Appeal Decision

Appeal Ref: APP/R5510/D/22/3306490

41 Highfield Drive, Ickenham UB10 8AW

DRAWING PROPOSED PLANS

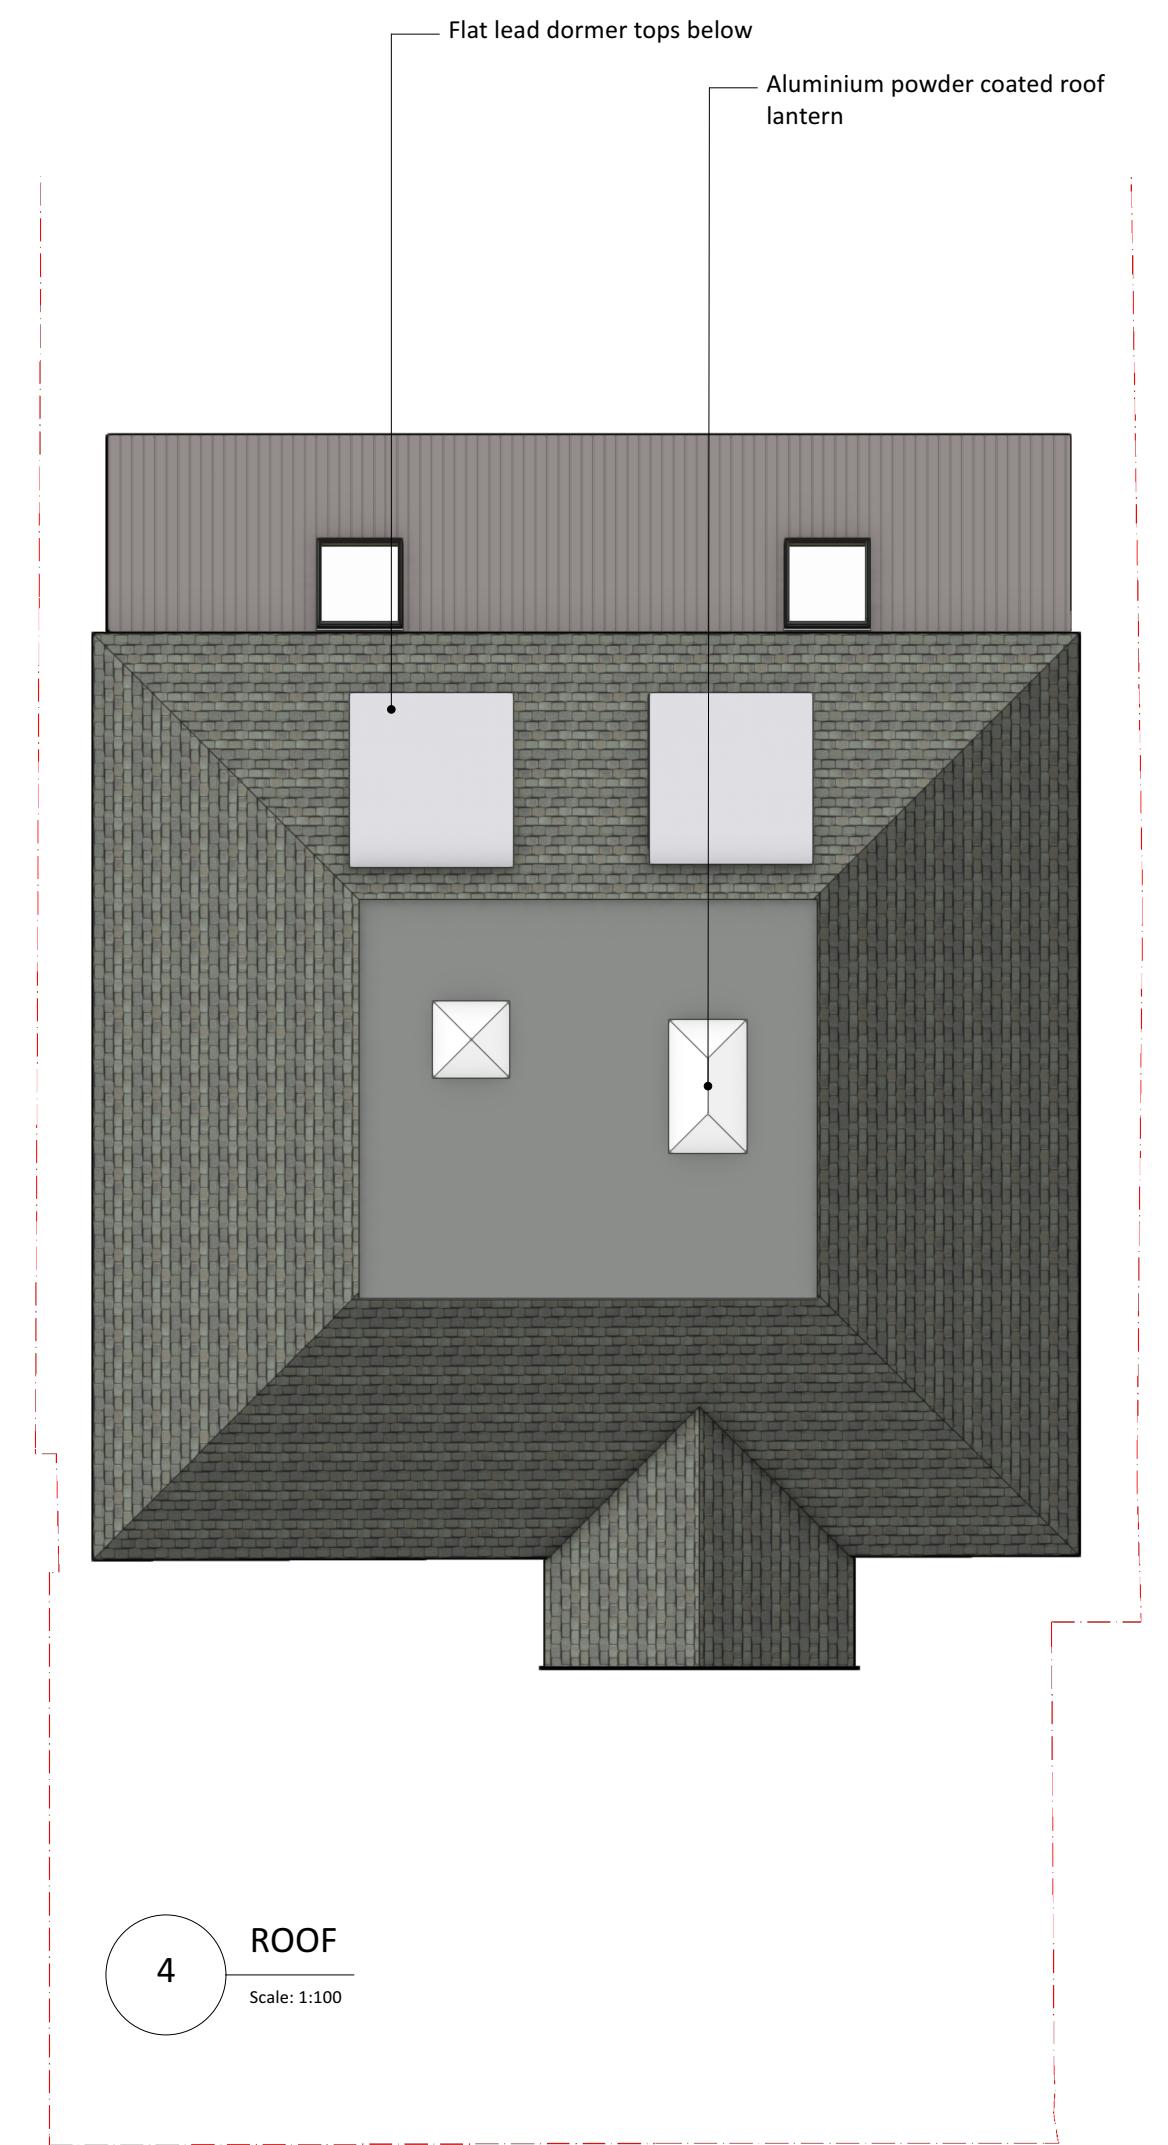
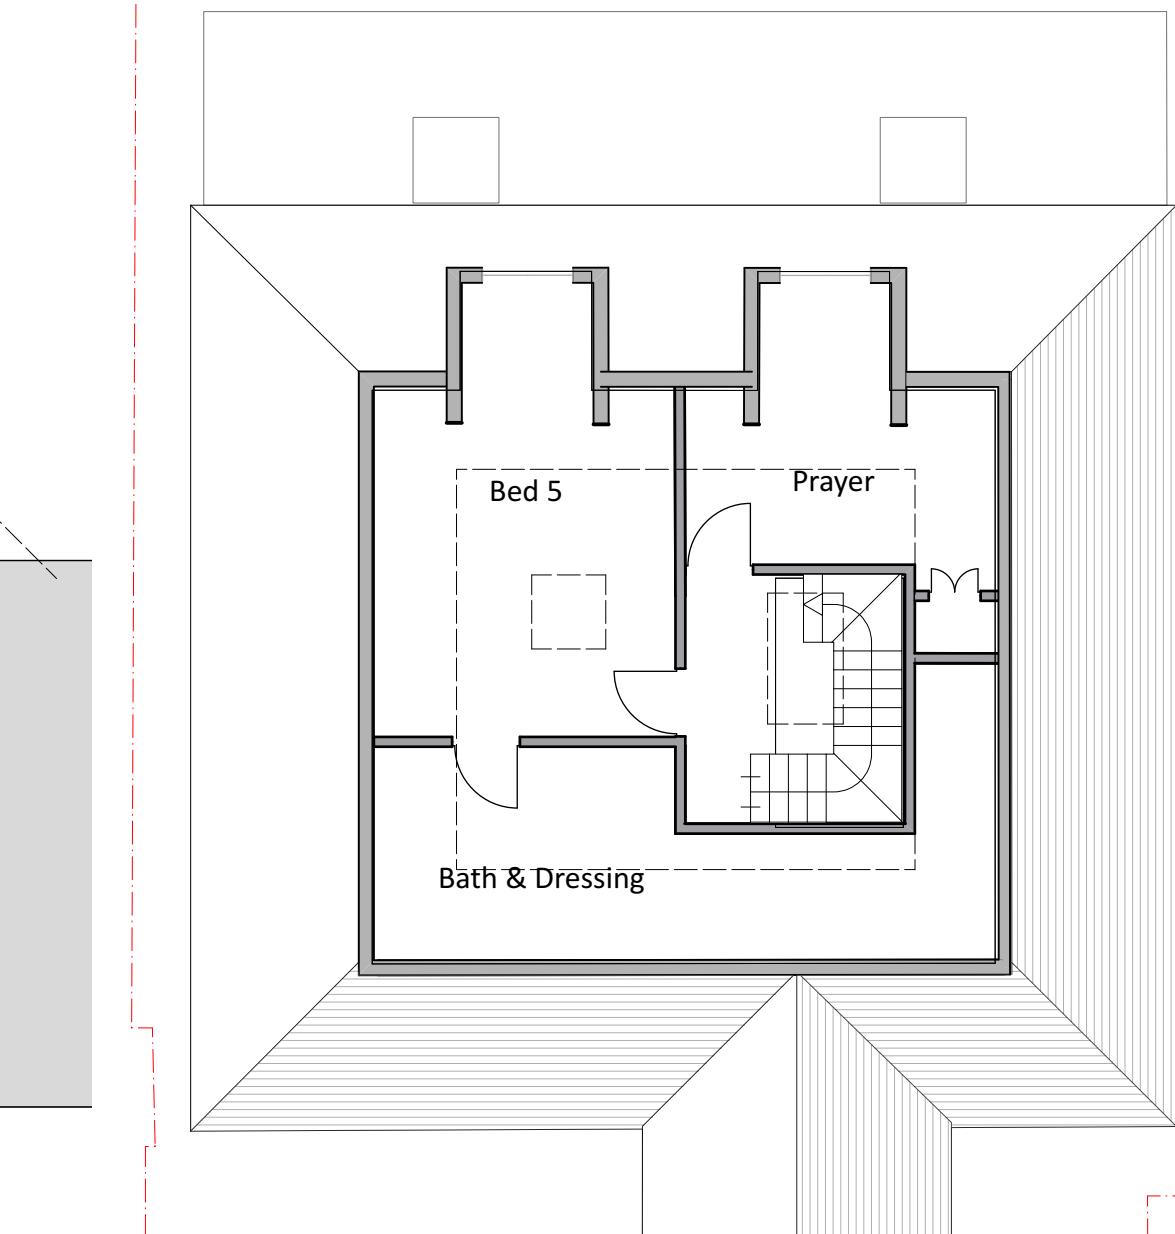
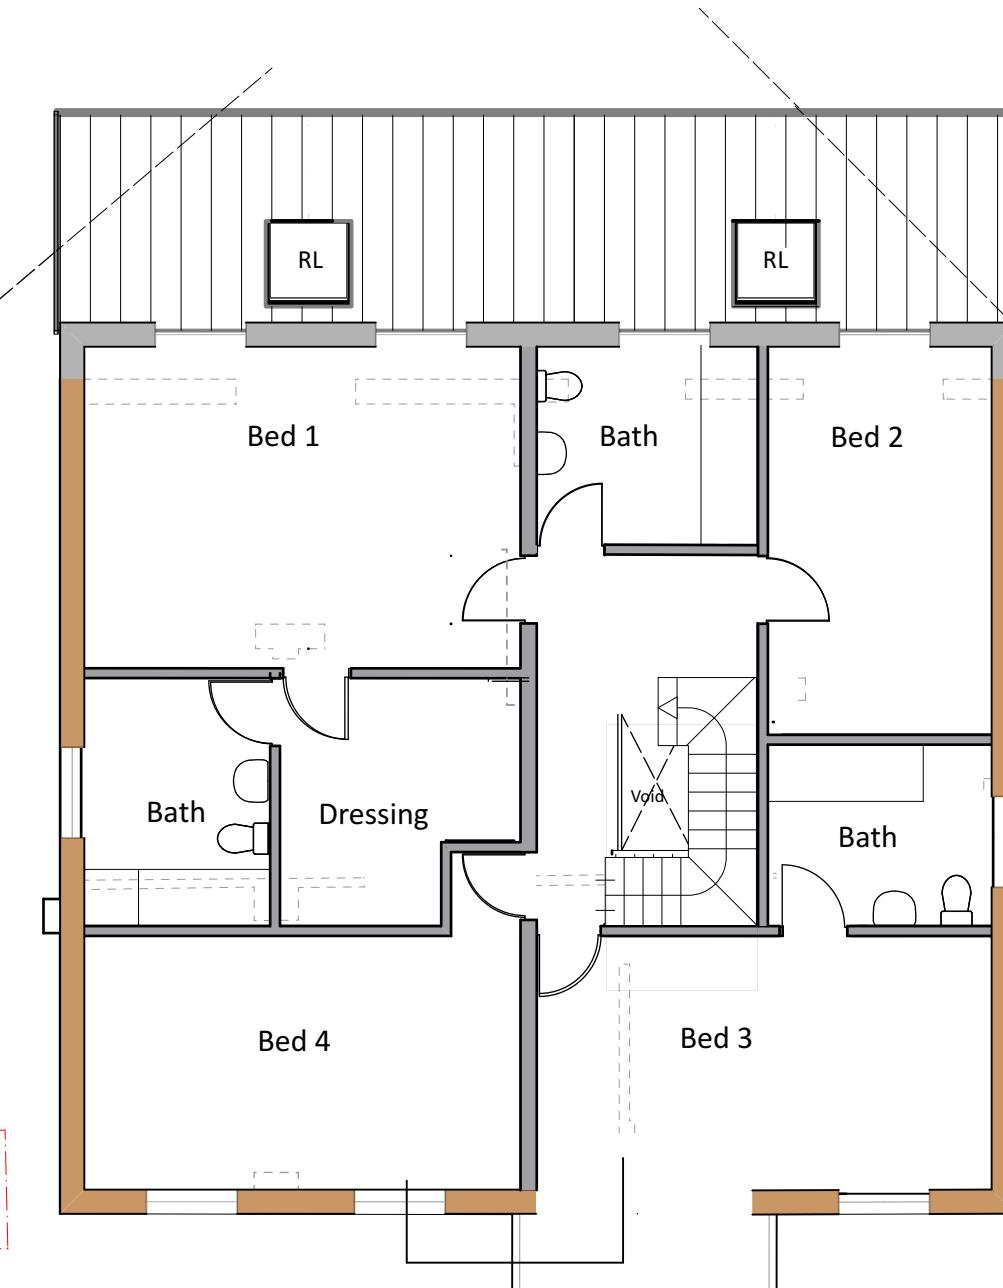
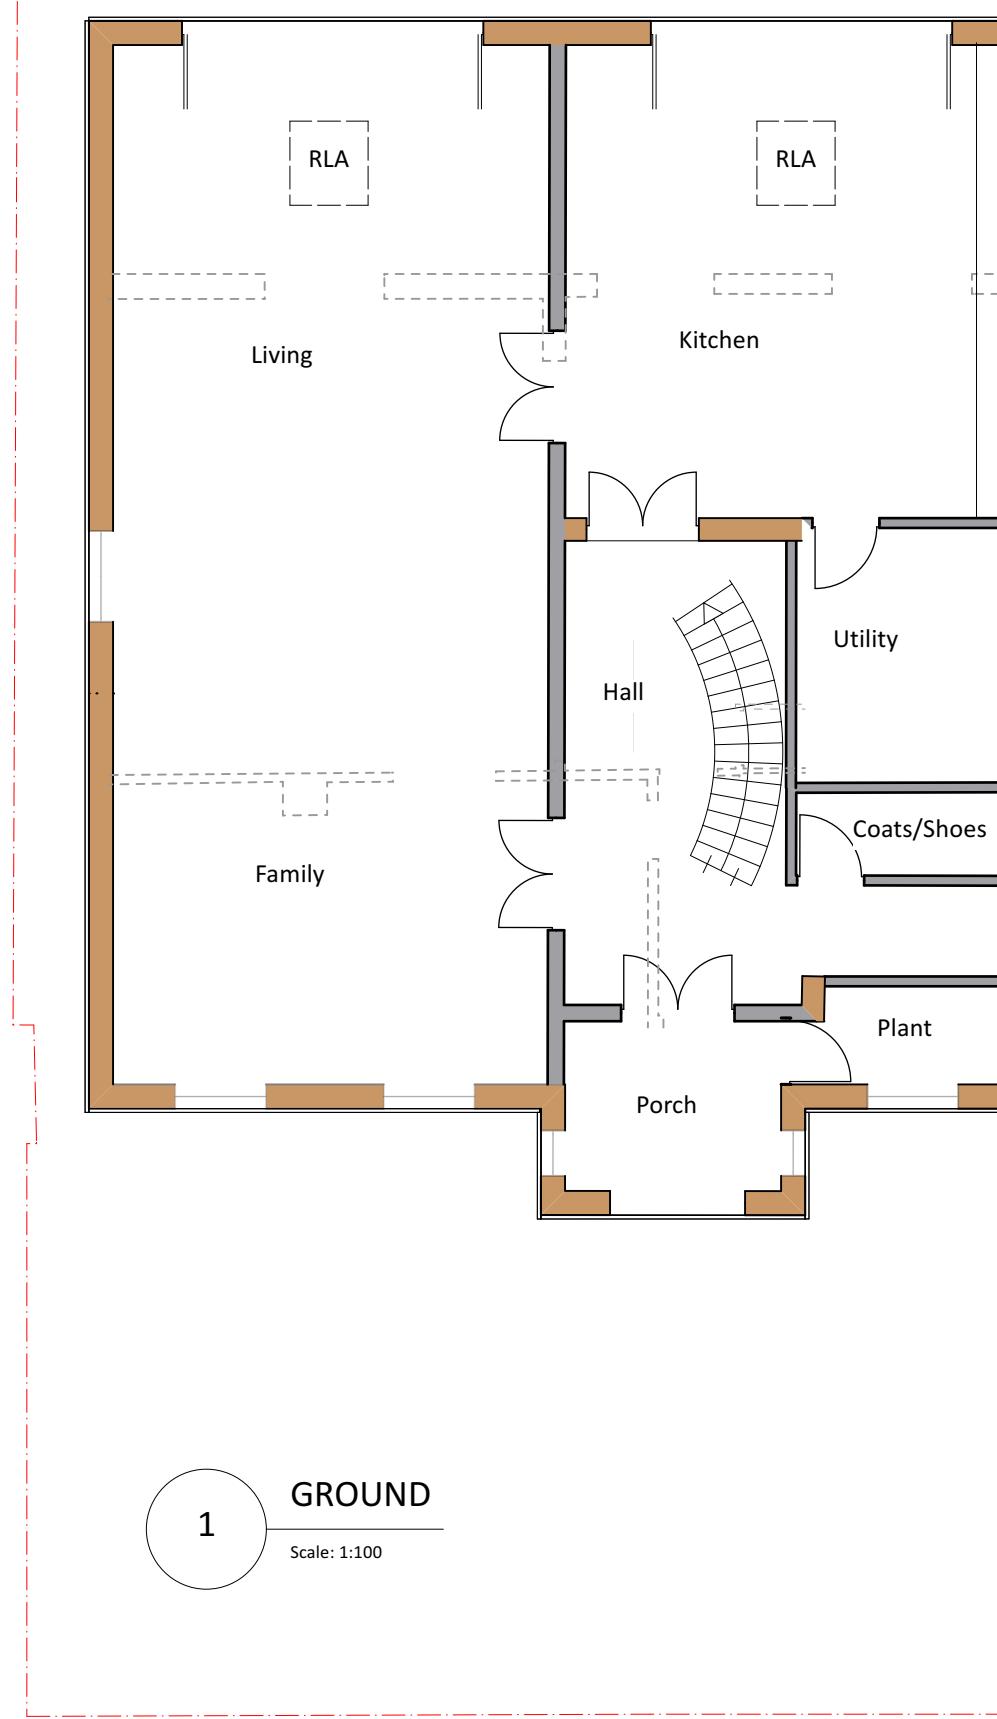
4. The appeal dwelling has been previously extended to the side and rear, and the Council indicates that the further rear extensions now proposed would project around 7m from the original rear building line at ground-floor level. Although it would significantly exceed the maximum depth for rear extensions specified within Policy DMHD 1 of the Local Plan Part 2 Development Management Policies 2020 ('the LPP2'), the resulting depth of the dwelling would not in itself be markedly out of keeping with other nearby buildings.

5. Nevertheless, the rear extensions would span the full width of the dwelling, and the proposal includes a crown roof with rear dormers and a large flat section

that would significantly increase the scale, mass and bulk of the upper part of the building. I observed crown roofs to many other dwellings nearby, but it appeared to me that most of the existing examples were typically of more modest dimensions, and the flat section to the appeal dwelling would certainly be one of the largest in the vicinity. While non-subordinate extensions and a change to the appearance of the dwelling would not necessarily be striking given the mixed street scene, I consider that the large upper bulk of the dwelling would give it a top-heavy appearance.

11. At first-floor level, the proposal would result in only a fairly small increase in the depth of the closest part of the building to No 43. However, the deepest part of the dwelling currently has a hipped roof which is substantially lower than the main roof. In contrast, the crown roof now proposed would extend out over the extensions to the rear of the building, and would be of greater height than the existing main roof and taller too at the eaves. Despite the small increase in depth, there would consequently be a considerable increase in the overall bulk and mass of the development closest to No 43. The proposal also includes a single-storey element that would further increase the depth of the ground-floor level, albeit that this is of modest height at the deepest part.

DRAWING PROPOSED ELEVATIONS & SITE LAYOUT

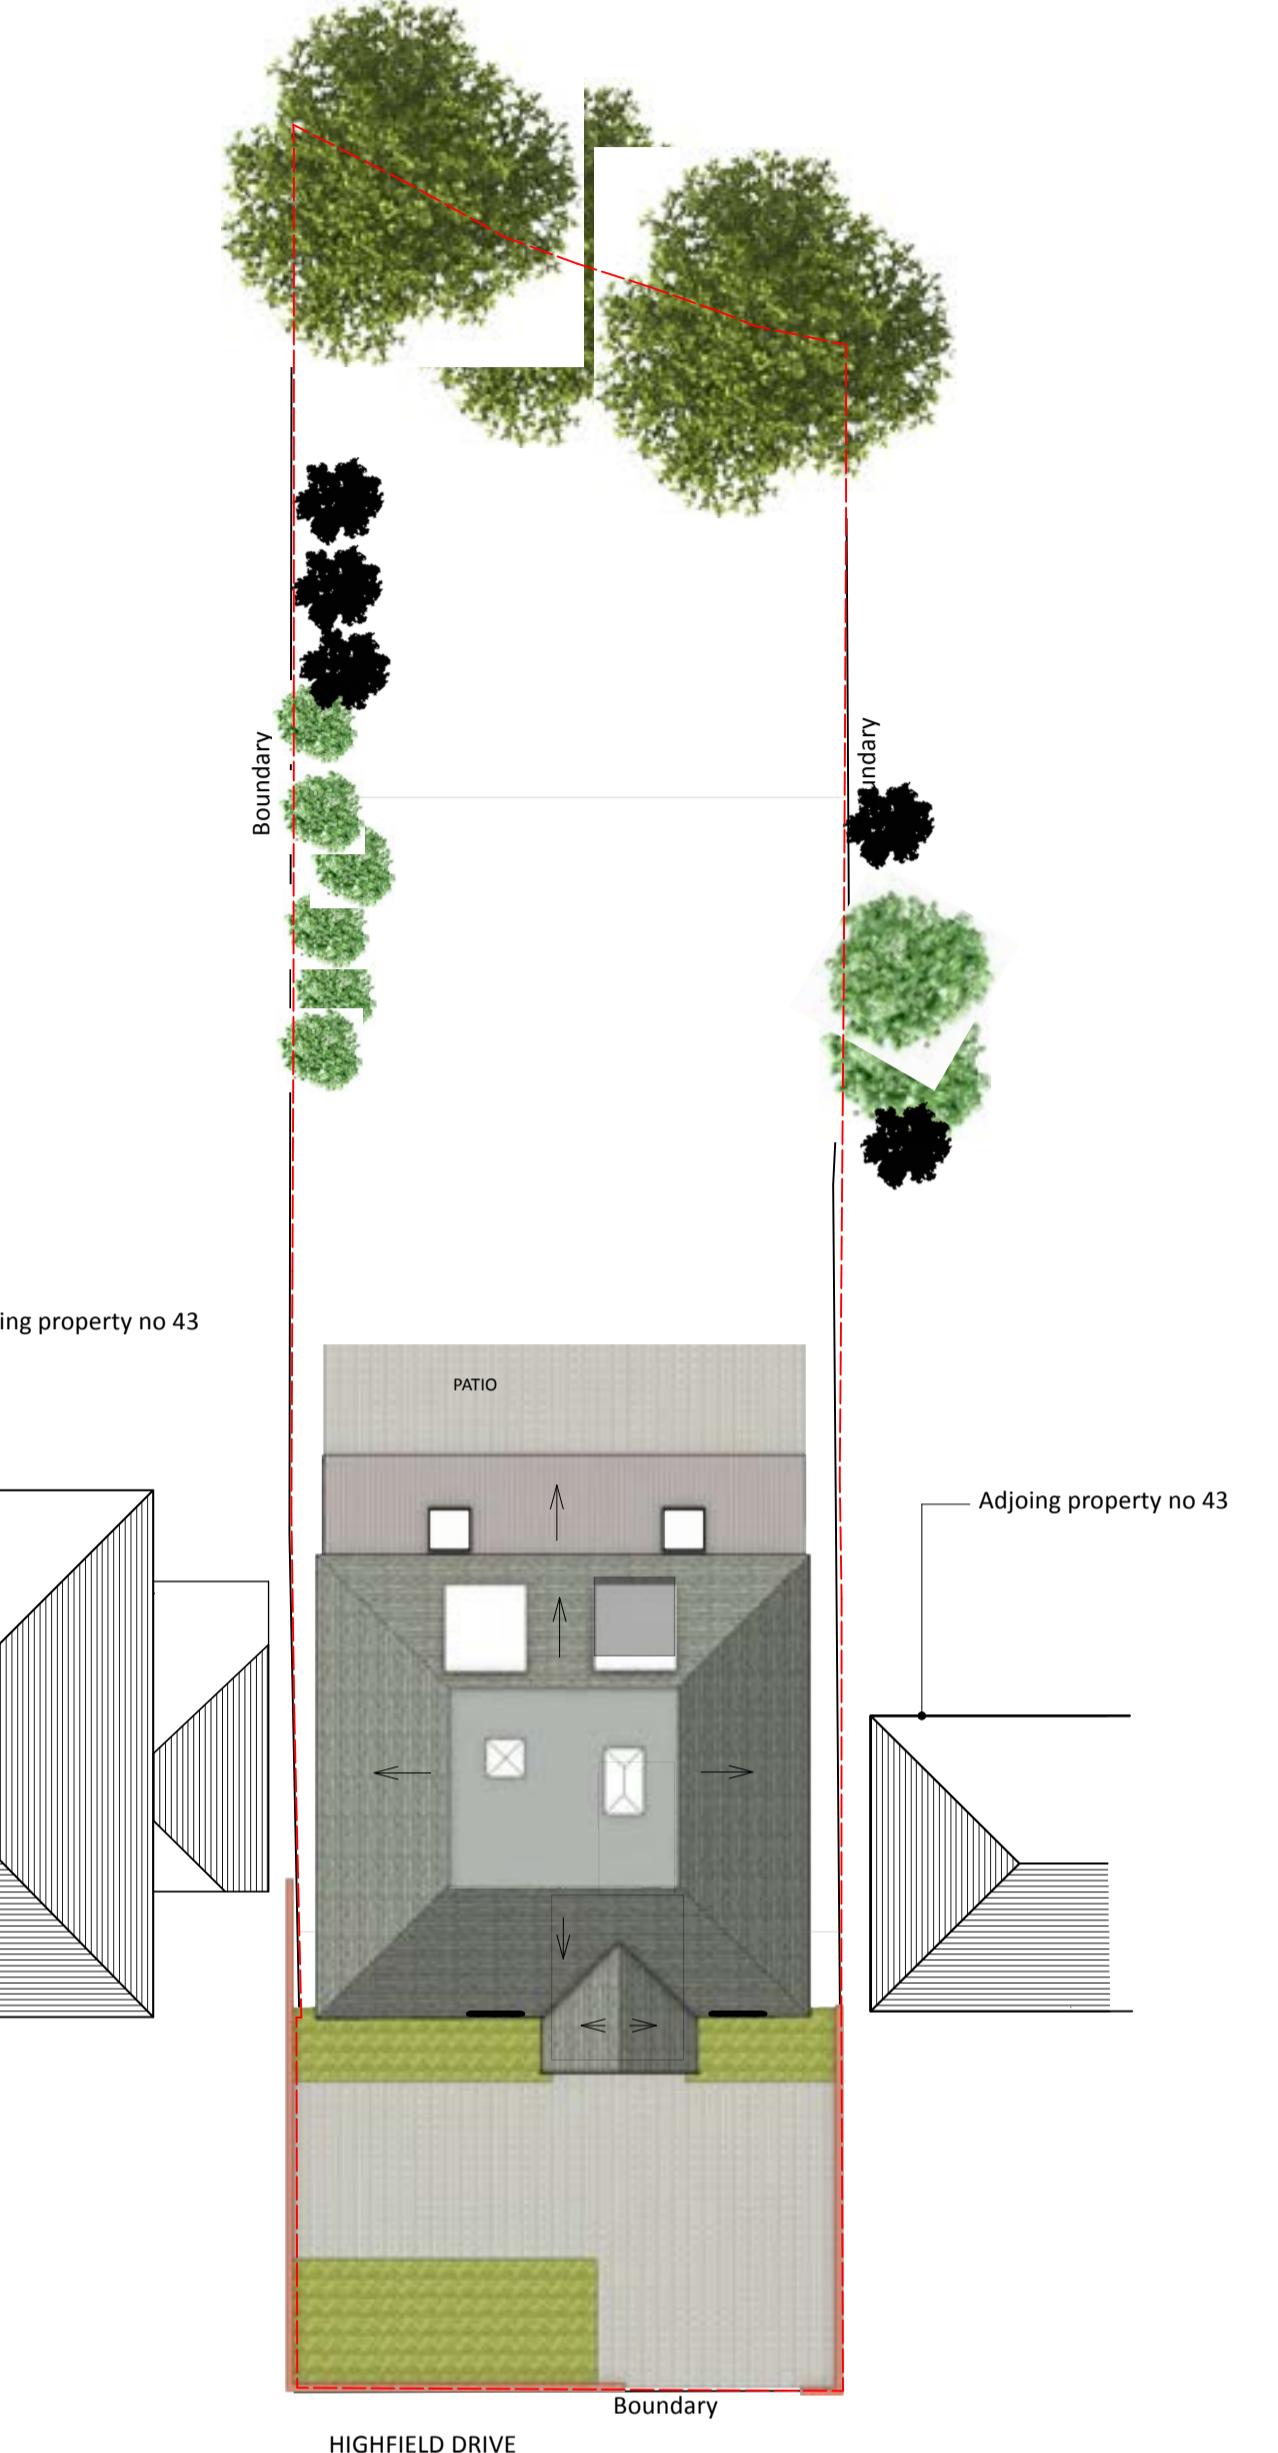
6. In addition, the proposal includes an increase in the height of the roof and eaves of the dwelling. Buildings on this part of Highfield Drive step generally down in height towards the south as land levels fall. The appellant suggests that the submitted plans show the relationship with neighbouring buildings accurately, but the outlines on the Proposed Elevations & Site Layout drawing show the eaves and roof of the existing appeal dwelling as lower than those of the neighbour at 43 Highfield Drive to the south. This is inconsistent with my observations at my visit where the eaves and roof of the appeal dwelling appeared to sit clearly above those of No 43, and as a result I am not persuaded that the illustrated relationships are representative.

7. The increases in the height of the roof and eaves of the dwelling may be fairly modest, but it seems to me that they would further increase its apparent height above No 43, and would reduce if not eliminate the existing step down in height from 39 Highfield Drive. This would disrupt the general pattern of development along this part of the street, and the height of the dwelling relative to its neighbours would draw further attention to the roof of the appeal dwelling causing it to appear conspicuous.

8. Furthermore, the relationship of the appeal dwelling with No 43 allows for simultaneous views of the ridges to the front and side of the building so that the presence and broad scale of the small existing crown roof is apparent. These views of the roof would be maintained if not increased given the greater height of the development above No 43. The bulk of the dwelling would therefore be appreciable, and while No 39 would provide some screening of the roof in views from the north, I cannot agree with the appellant that the crown roof would not be readily visible. In this respect, the proposal can be distinguished from permission granted on appeal for redevelopment of 38 Highfield Drive where the appellant has quoted sections of the decision which refer to screening of the crown roof offered by the neighbouring dwelling and existing vegetation.
